DRB-1005220

DRB CASE NO/PROJECT NO: 1005220

Sketch Plat

**PLAT OF  
TRACTS A, B, C, & D  
LANDS OF JOHN S. PALONI**

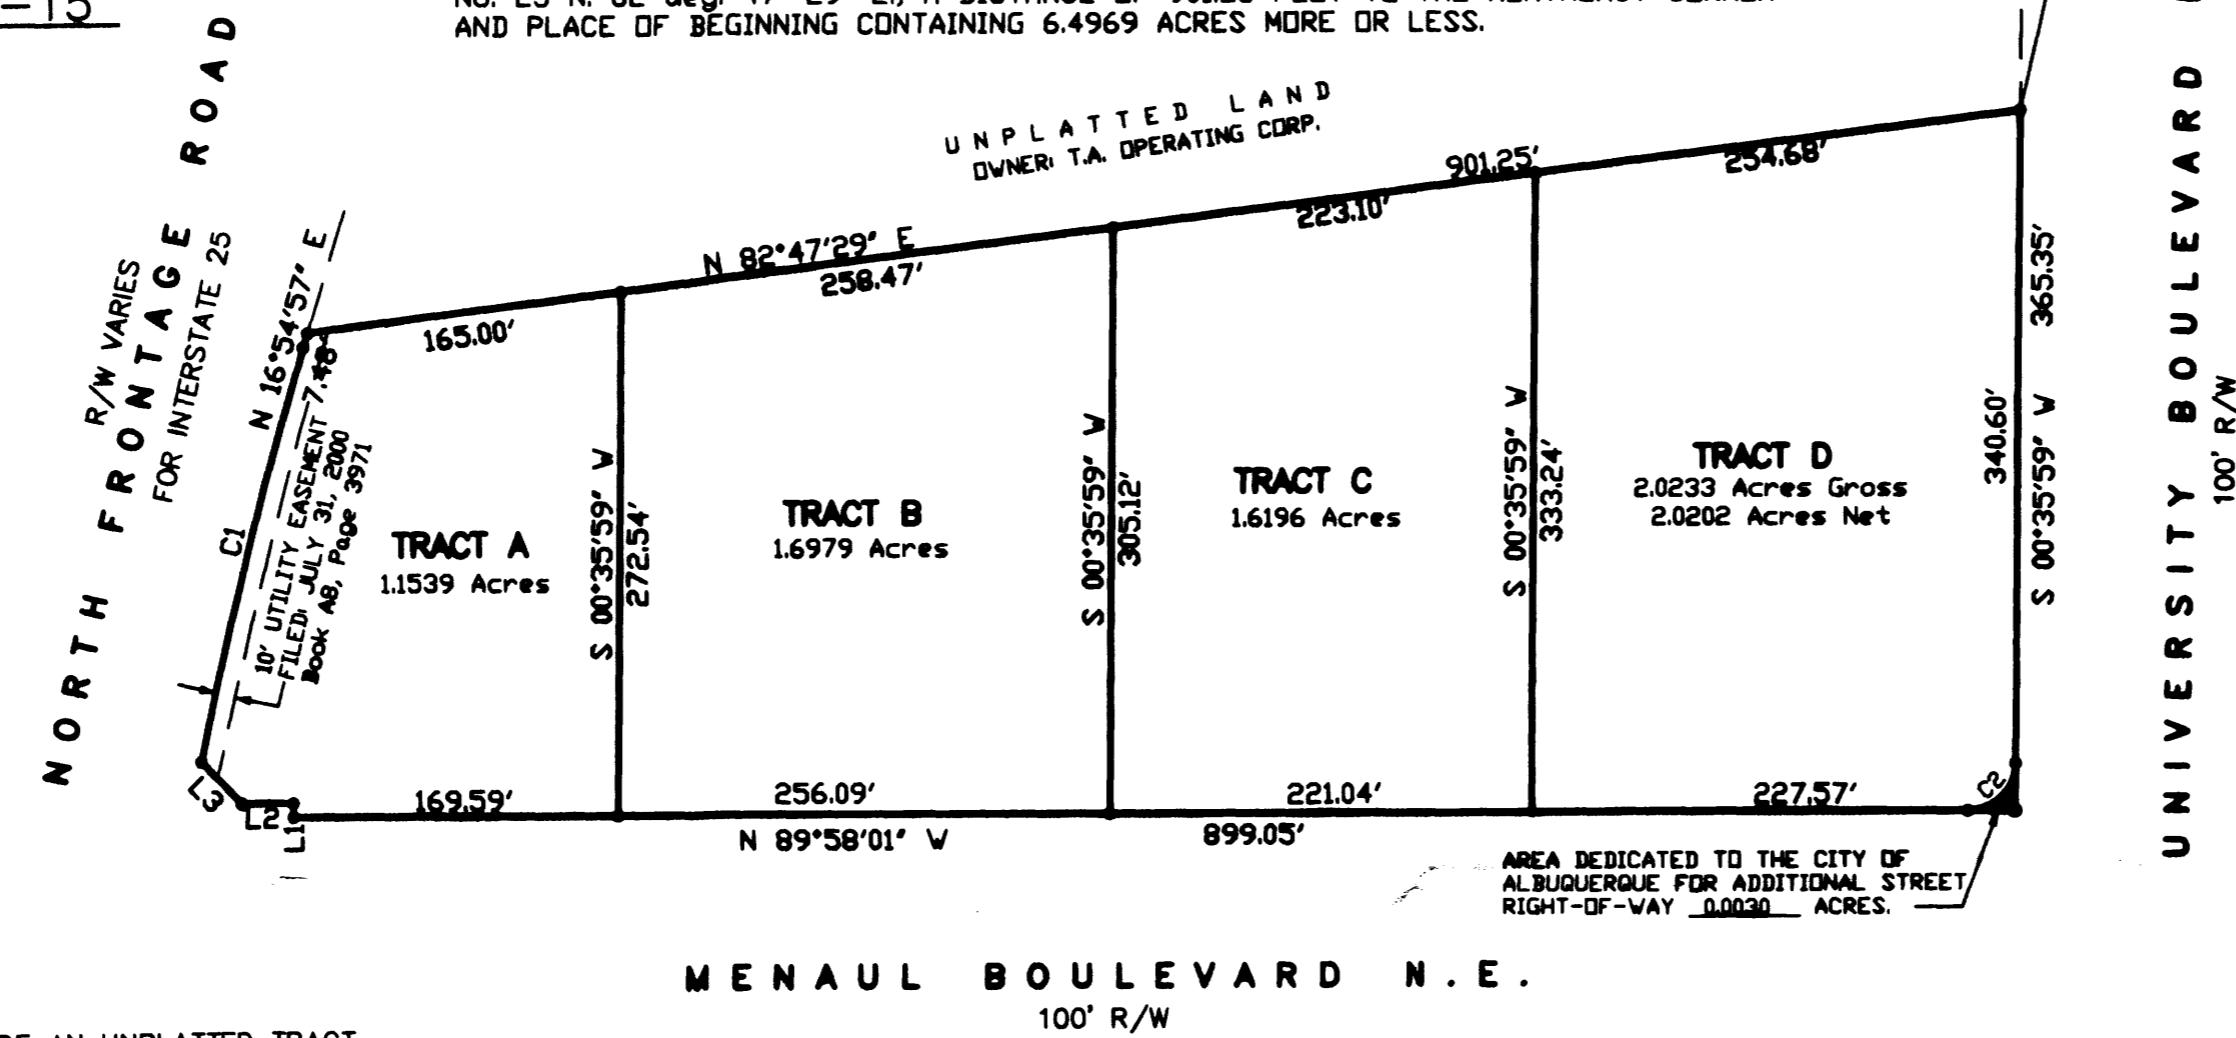
1. There are no serviceable water or sanitary sewer lines in Menaul. Subdivision will require the design and construction of water and sewer lines to serve the lots. A water/sewer Availability Letter should be requested.

A cross lot drainage easement is required.
